4	Section 4 — History and Heritage	8	Of note, 50% of the housing in Phibsboro is Victorian and the plans for the stations do not appear to reference any of the area’s long history and heritage. For example, below are two images of views of the proposed Mater Station showing the station view in front of the Mater Hospital and the other of the block housing ventilation and metro plant machinery.	<p>TII believe the commissioning of internationally renowned architect Nicholas Grimshaw and Partners, has delivered a contemporary station design which is appropriate for a state of the art metro system such as MetroLink. Appropriately, significant emphasis is placed on the public spaces. Where feasible, the station concourse is a soaring space illuminated from above with natural light. Dublin's rich architectural heritage has been respected, but not copied in a pastiche imitation. In accordance with best conservation principles, as set out in the ICOMOS Venice Charter of 1964, the stations are architecturally distinguishable so as not to falsify the existing historic context. Reference and due respect to that context is made through the choice of high quality and appropriate materials and t

Client	TII NTA	Project	METROLINK	Drawing Title	METROLINK- STRUCTURES GLASNEVIN STATION PROPOSED STREET LEVEL DESIGN	Drawing Status	S0
Consultant	JACOBS IDOM	Drawing N°	ML1-JAI-SRD-ROUT_XX-DR-Y-02057	Plan Drawing N°	ML-ST 304 N-01	Sheet 1 of 8	
Scales Original Size A1		1:250

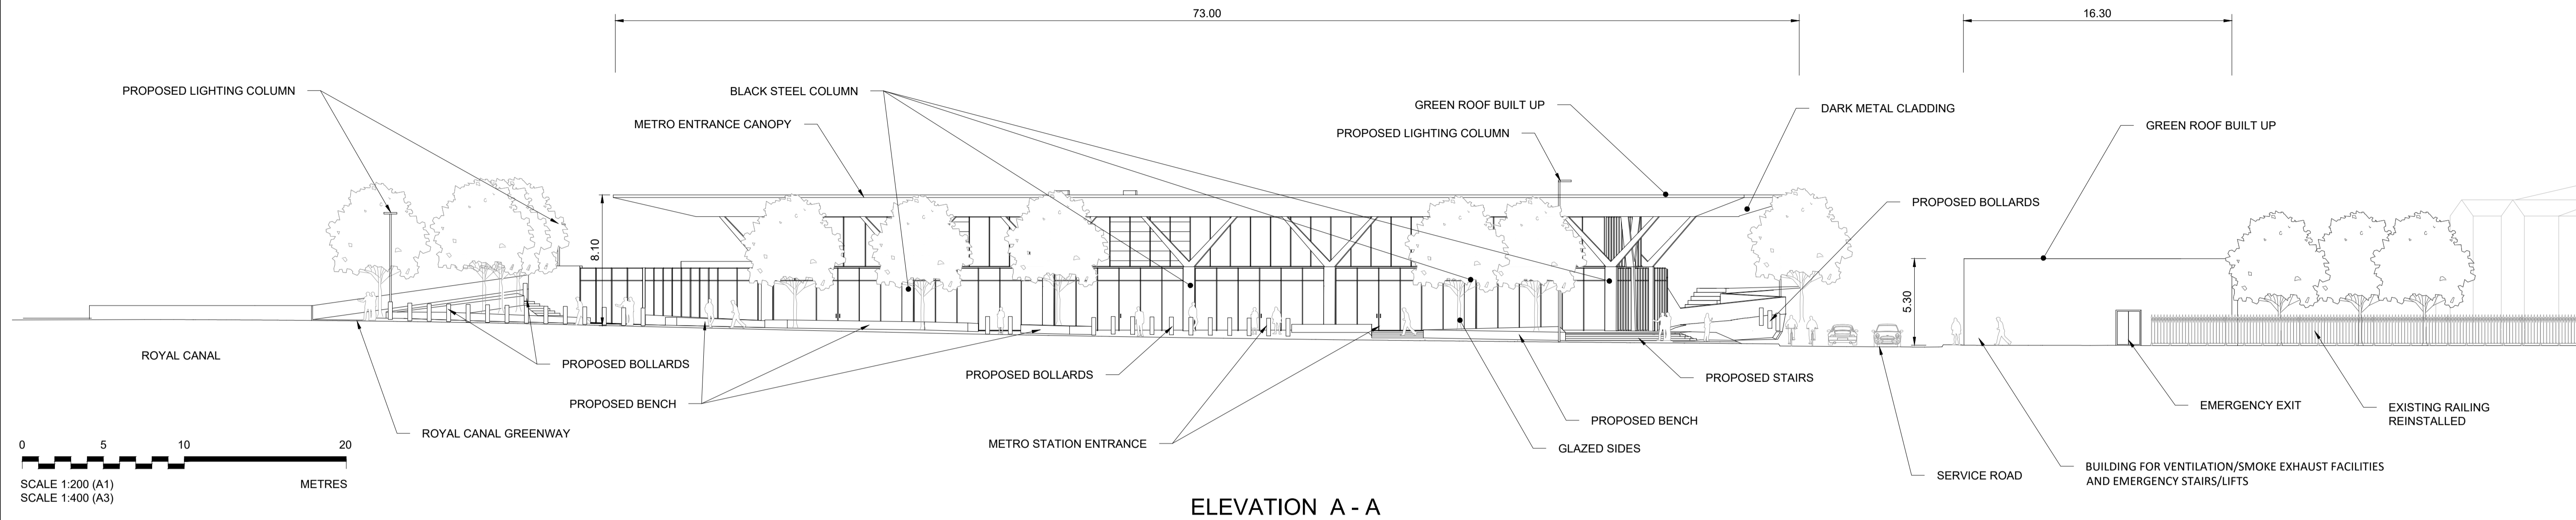
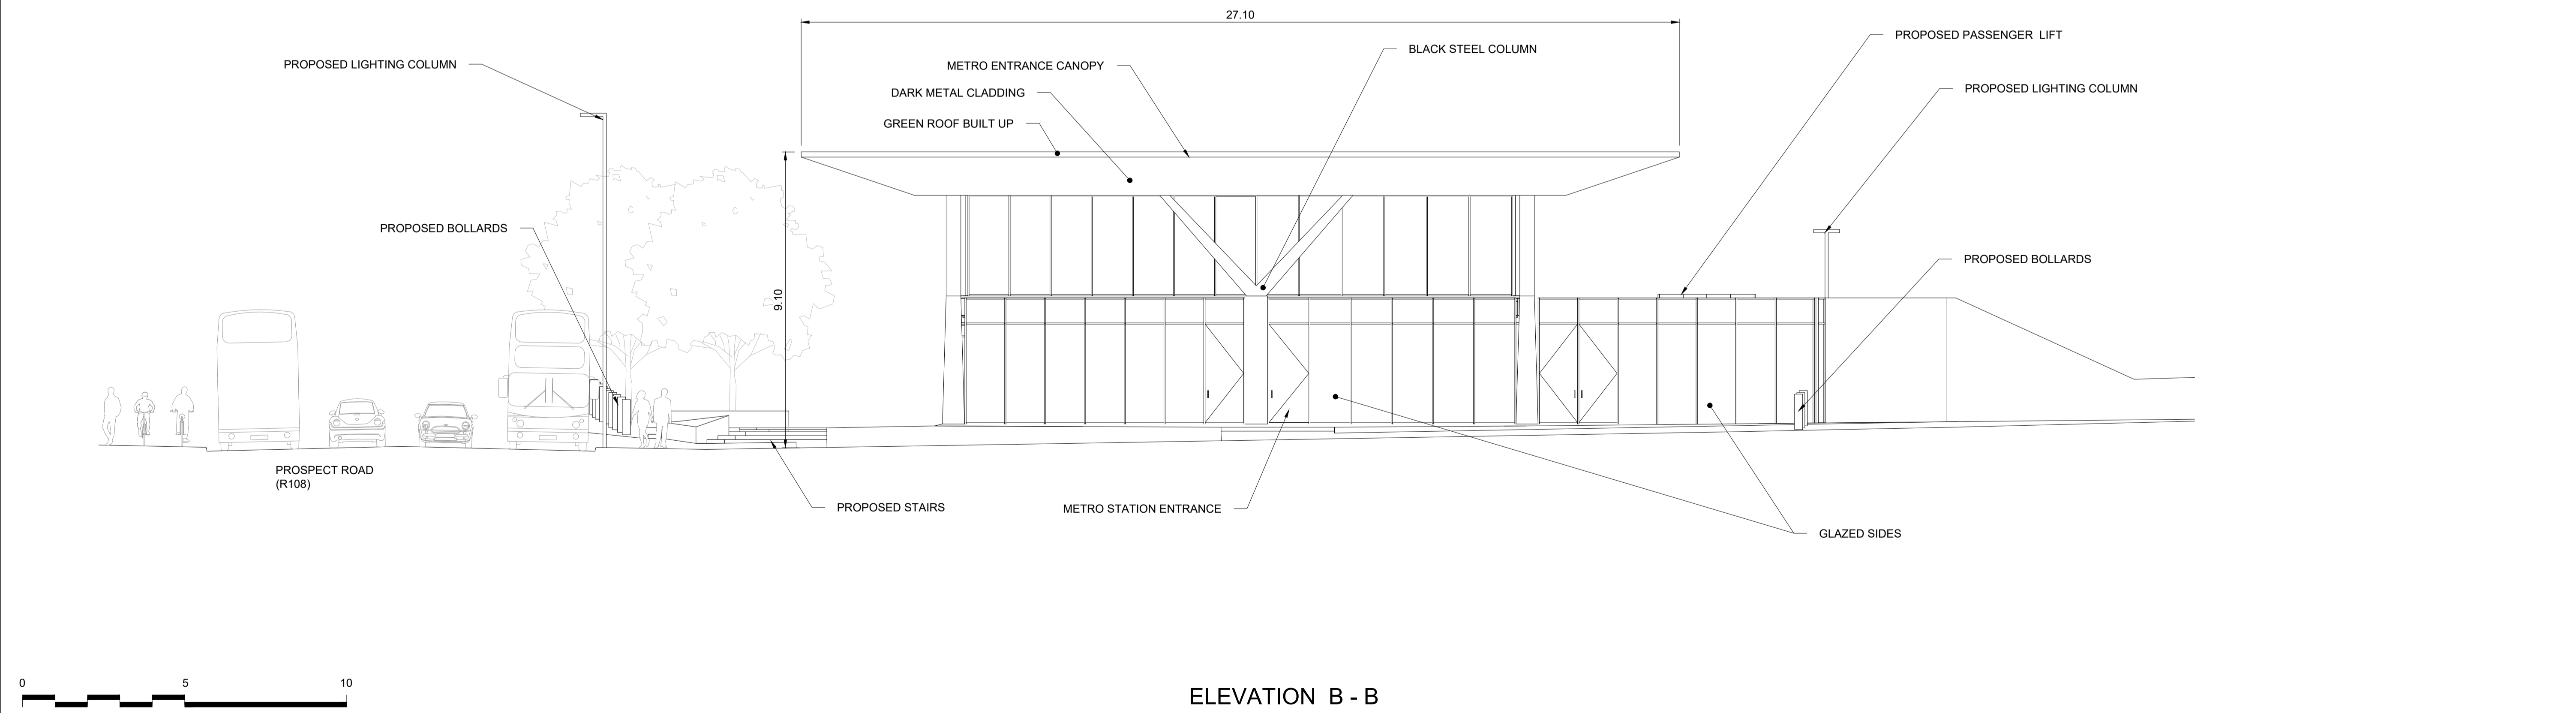
11	Section 5 — Planning conditions	9	<ul style="list-style-type: none">• Open Public Architectural Competition to design Glasnevin and Mater Stations. The designs shown in the plans do not appear to reference any of the rich heritage and history of this area of the city. For example, Glasnevin Station will sit alongside the cornerstone of the Royal Canal, where its building works began in 1790 and the Brian Boru pub is an important historic site where Brian Boru gathered his army in defence of Ireland prior to the Battle of Clontarf.	<p>Please refer to response item (4) and (5) in relation to the architectural design of both Mater and Glasnevin stations, and all stations within the Project.</p>
